Application Reference: 2025/0083**Site Address:** Illton House, Roper Lane, Thurgoland, Sheffield, S35 7AA

Introduction: This application seeks full planning permission for the Removal of integrated garage roof and replace with first floor side extension to create extra bedrooms, demolition of existing single storey rear extension and replace with new single storey rear extension, to 2 storey detached dwelling.

Drawn	CJA
Date	Nov 2024
Scales	1:100 @ A1
Drawing No.	2467 - 0301 - P02

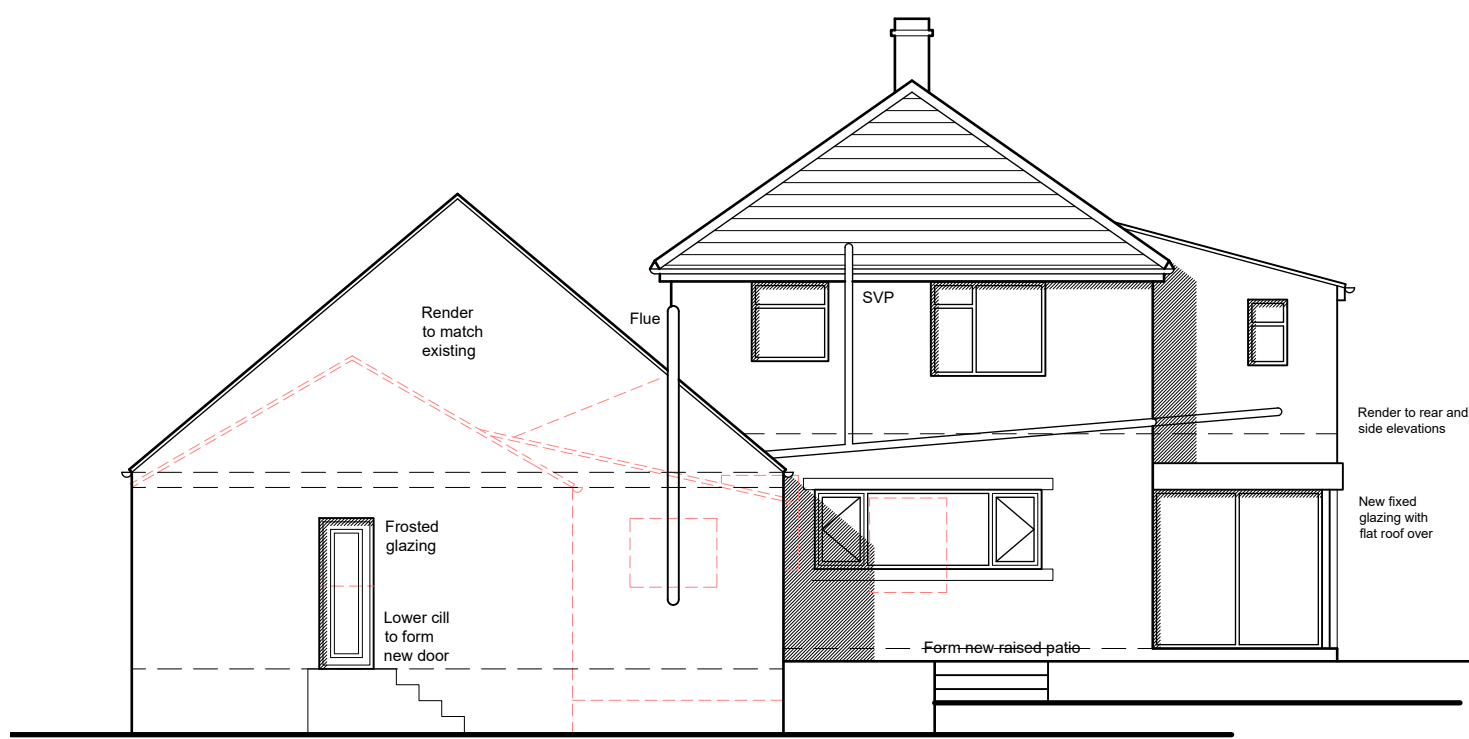
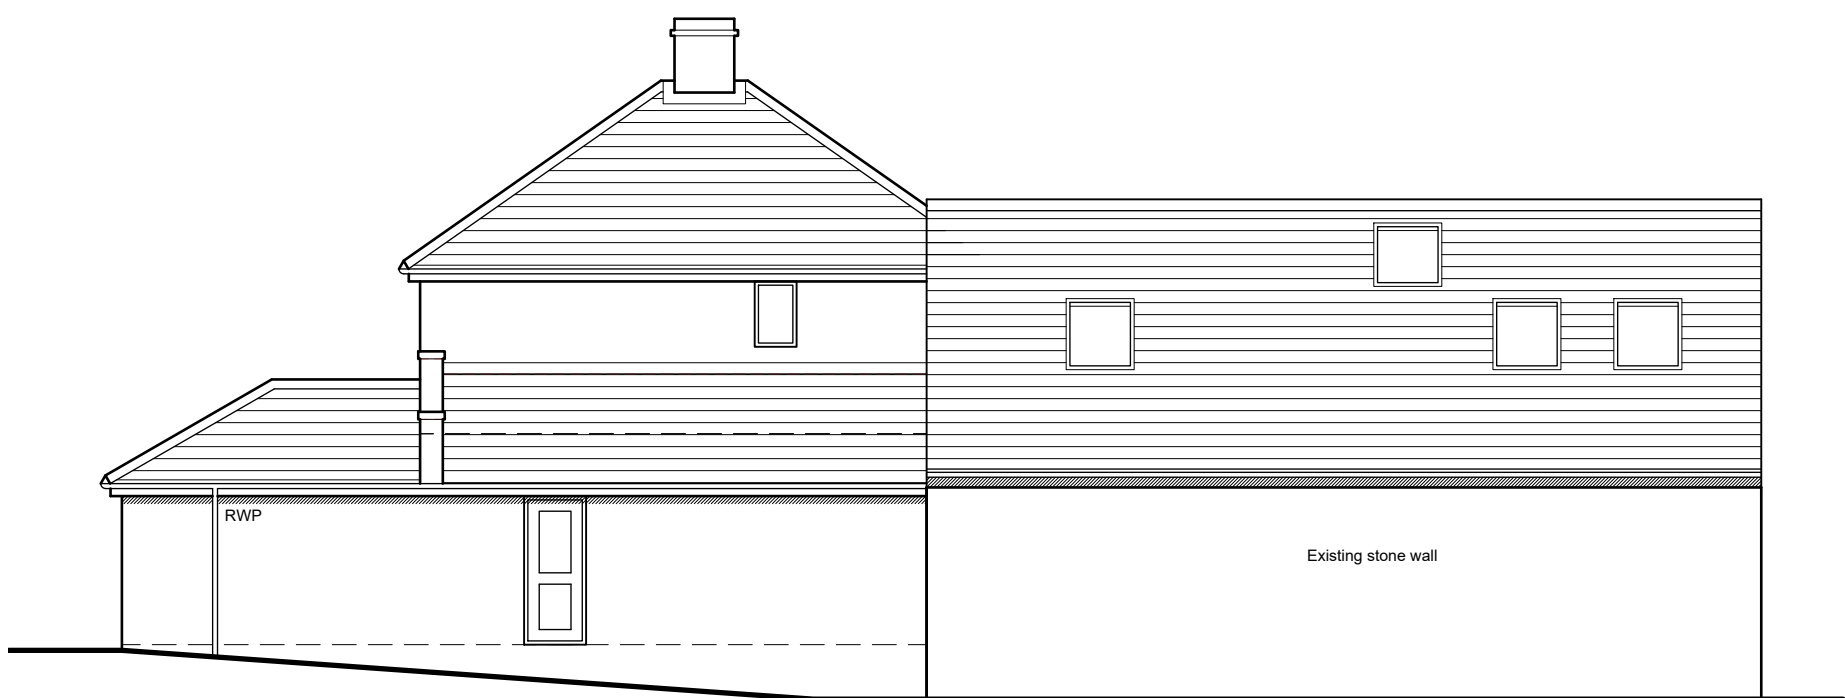
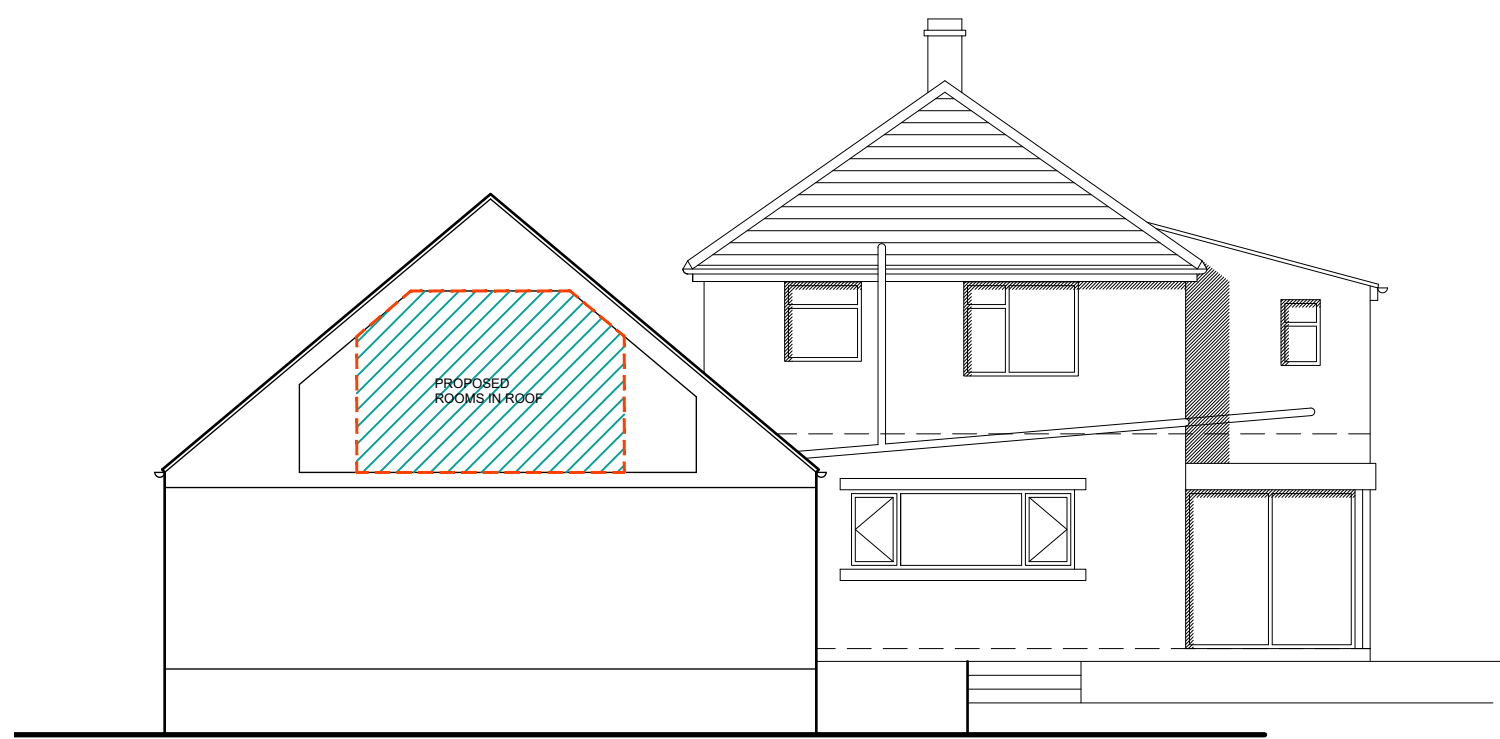
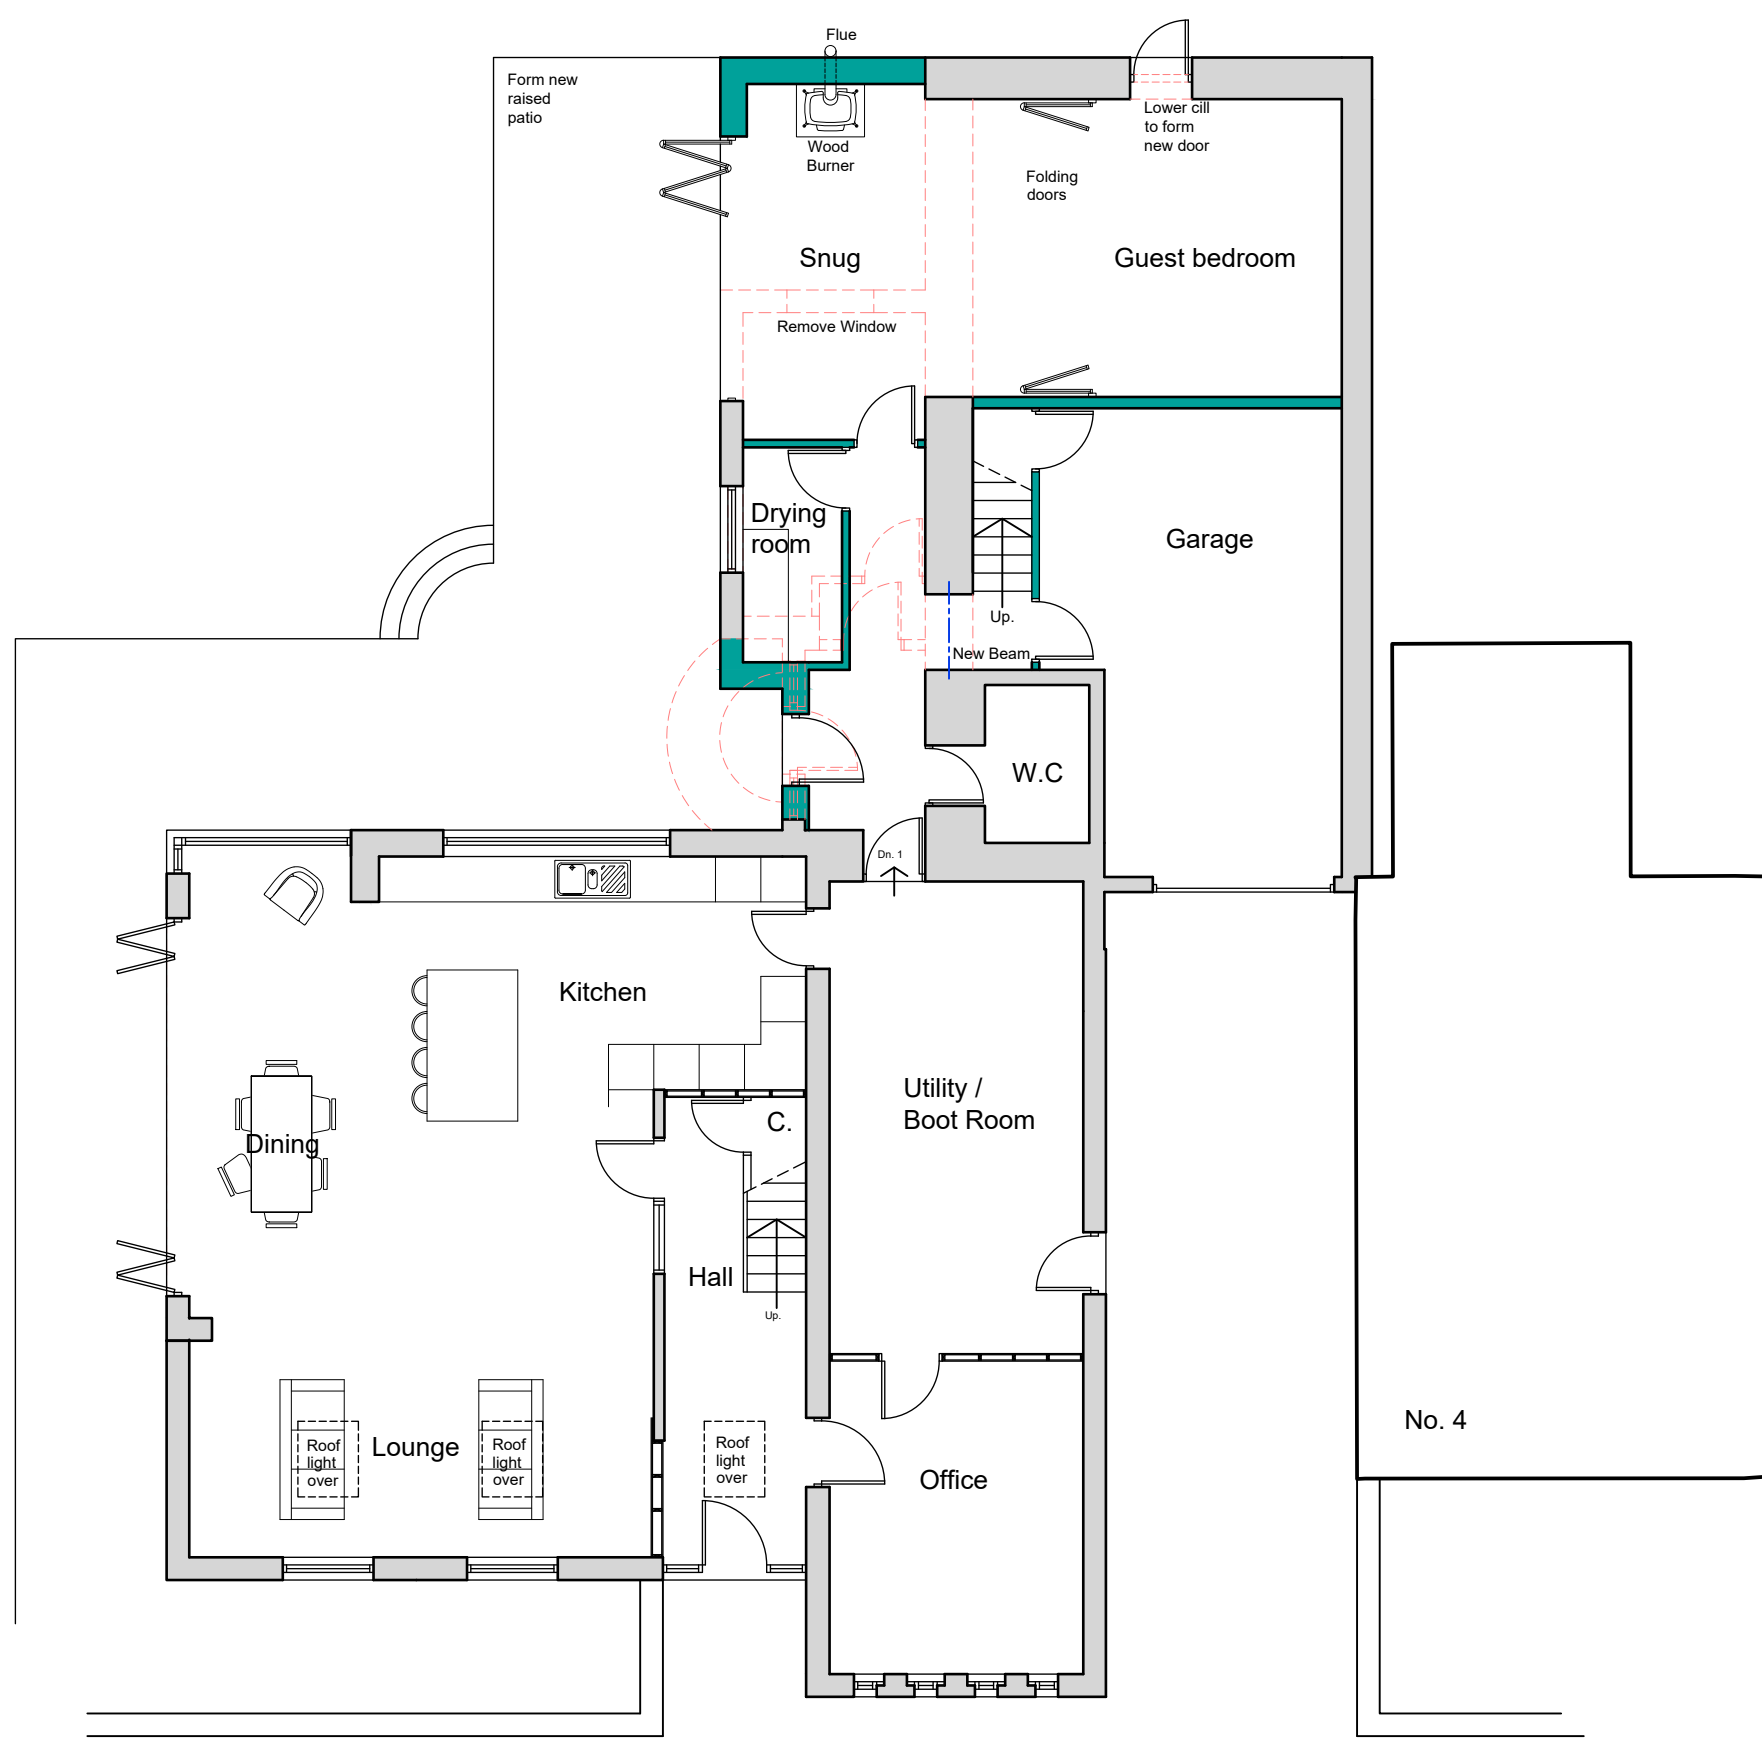
The most significant and prominent aspect of the proposal would be the enlarged new roof which is proposed to cover both the existing garage and new/extended rear extension, allowing additional living space to be created within part of the roof above the garage and the rear extension. Due to differing ground levels, the height of the roof is measured at 5.82m on the front elevation, 6.95m on the rear elevation, and 6.43m from the ground level on the northeast elevation. The proposed materials for the gable aspect of the roof are proposed stone/facing stone to match the original brickwork of the house, whilst the roof would be tiled.

The scale of the dwelling is already unusual and relatively large. The proposals are for a new roof above the existing garage, which would be internally combined with the new/ reconfigured extension to living space. These works would add additional height and volume above the garage and reconfigured rear extension which is already attached to the garage. The increase in height would be at a considerable distance from the highway and be lower than the existing 7.5m of the main roof of the dwelling. With a gable style roof, whilst the maximum ridge height of the roof, viewed from the Roper Lane is approximately 5.81m high, this level drops as the roof slopes to both sides. Because of land level differences, the roof is approximately 6.95m when viewed from the rear of the house, but again this remains lower than the 8.65m height of the main dwelling. Whilst the proposed roof height would have an impact on the scale of the dwelling, some of this impact would also be positive by harmonising the garage and rear extension under one new roof. Additionally, with such an unusual design of dwelling as a starting point, and with the green wooden cladding being replaced by stone or facing stone of a similar appearance to that of the main house, the overall impact on scale, design and character of the dwelling, and by association the street scene would be considered as limited.

The second aspect of the proposal is for the demolition and replacement, or renovation of the existing ground floor extension which is attached to the northwestern elevation of the garage. The replacement would include two small increases in the footprint of the existing ground floor extension. The first increase would be a corner infill of approximately 8.35m at the side and rear elevation whilst the second extension is of a relatively insignificant size of approximately 0.55 sqm and would be located close to where the side elevation of the extension adjoins the house. With the new proposed and heightened roof covering both the garage and rear extension the proposed extension would include first-floor living space within the new roof. Overall, the proposal would have a generally positive impact regarding the design and character of the

Objections have been received about the perceived impact of the proposed new garage and extension roof. The nearest dwelling is No. 4 Roper Lane which is already overshadowed but not overlooked by any windows from the existing garage. With the proposed gable roof design of the roof, which has a significant slope away from the neighbouring dwelling, it would only be expected to have little or no additional impact on their amenity. Dwellings further away from the proposal would have even less of an impact from the proposal.

Privacy concerns were raised about proposed roof lights located within the northeastern elevation of the proposed new roof, these would potentially overlook Cliffe Cottages, and a second concern was raised about a ground floor door within the north elevation of the former garage. The original proposed window within the door was already detailed as having frosted glazing and remains so on the amended plans. The proposed rooflights, although unlikely to have overlooked any neighbouring dwellings, are now also listed as having frosted glass. With both these issues resolved, no other proposed windows overlooking neighbouring dwellings, and with no other concerns raised being deemed as material planning considerations, the impact of the proposal on privacy or other neighbouring amenity would be judged to be limited.

- There were concerns over the proposed materials and size of the proposal. Revised plans with modest height amendments but greatly improved material choices were submitted, along with confirmation of frosted glazing in windows potentially overlooking neighbouring dwellings.
